From: Ruiz, Nina
Sent: Wednesday, January 18, 2023 1:13 PM
To: Ryan Howser
Cc: ryan@widefieldinvestmentgroup.com; Michael Kahnke; Andy McCord; Dossey, Craig
Subject: Glen #12 Comments

As we discussed, this email is a recap so that you may pass along to others as needed. The main topics we went over were the PLA, cul-de-sac radius, and soils and geology report.

### Dwarf Clover Knuckle and CDS

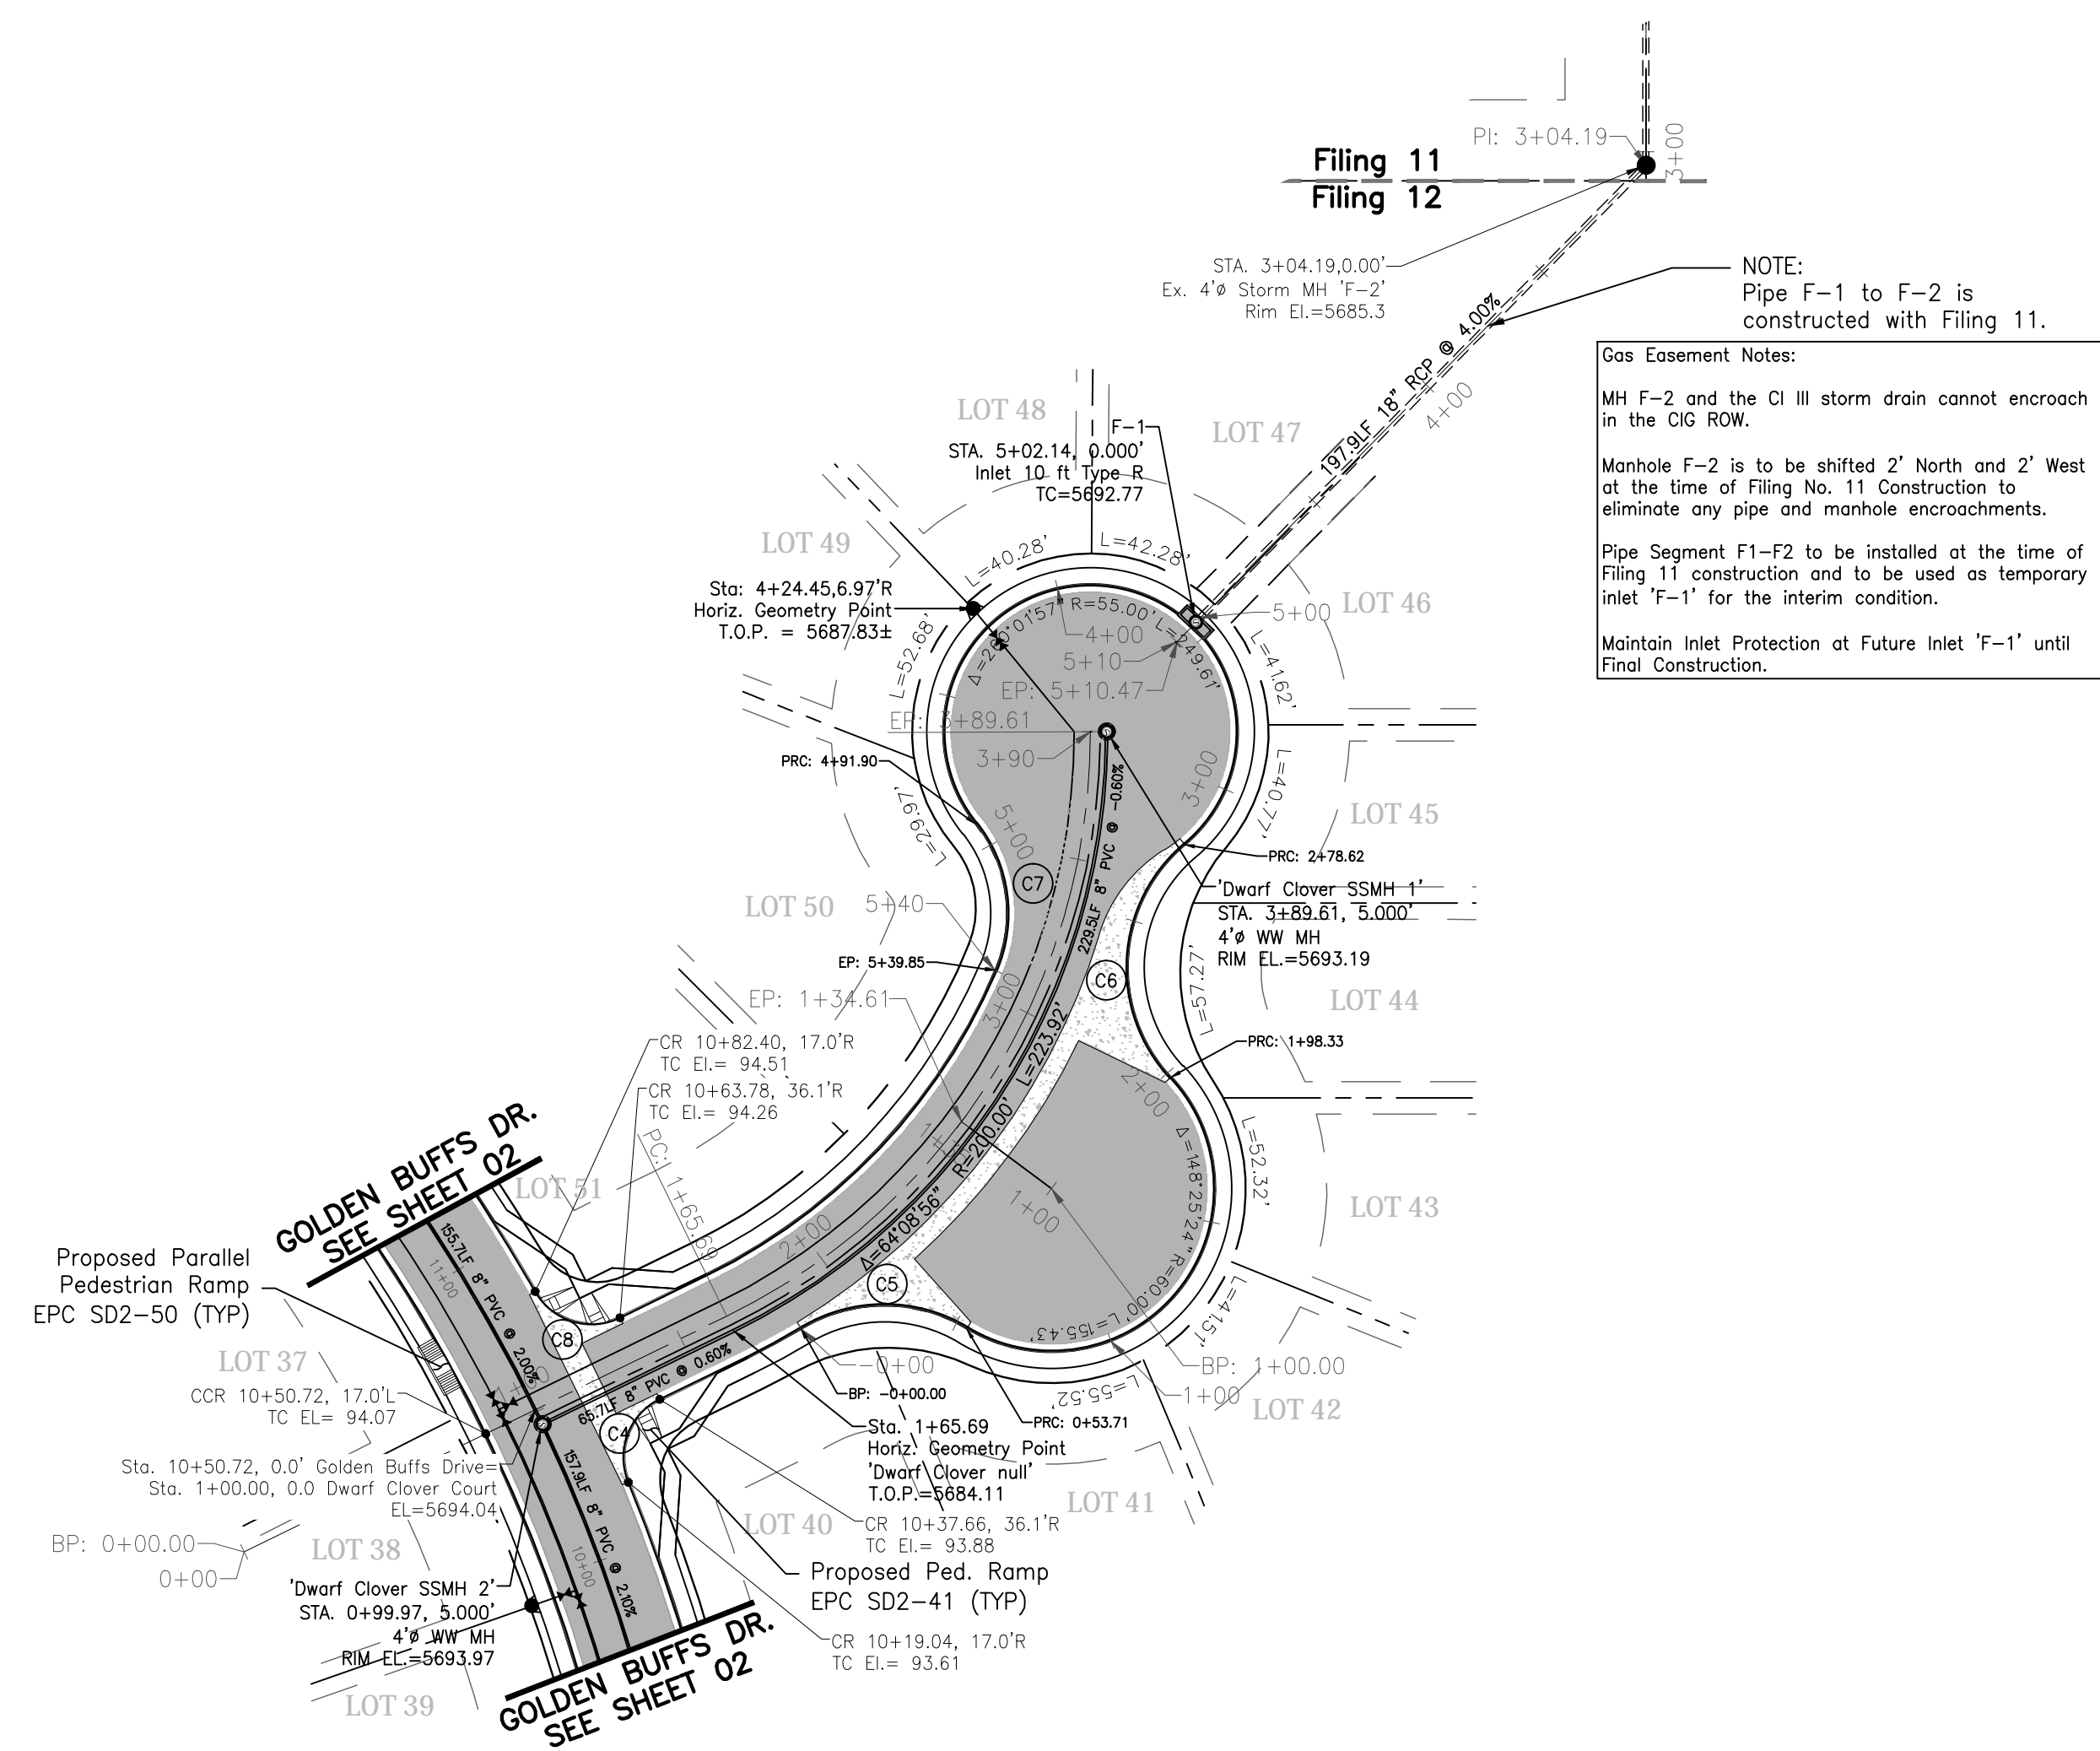
- Cul-de-sac: the plat was designed based upon previous criteria. We understand that we do not meet the criteria where the cul-de-sac necks down to the roadway and that we are not at the required 45' radius. If we go to a 45' radius we will impact the lots and may need to complete significant redesign of the lot layout. We propose to increase the radius from what it currently is to 37'. Prior to submitting the deviation, we want to know if engineering has any major heartburn with this approach, or if it can be supported. We completely understand that no approval or official determination can be made until it is submitted, but we did not want to waste valuable review time and time preparing the resubmission if it will go nowhere.
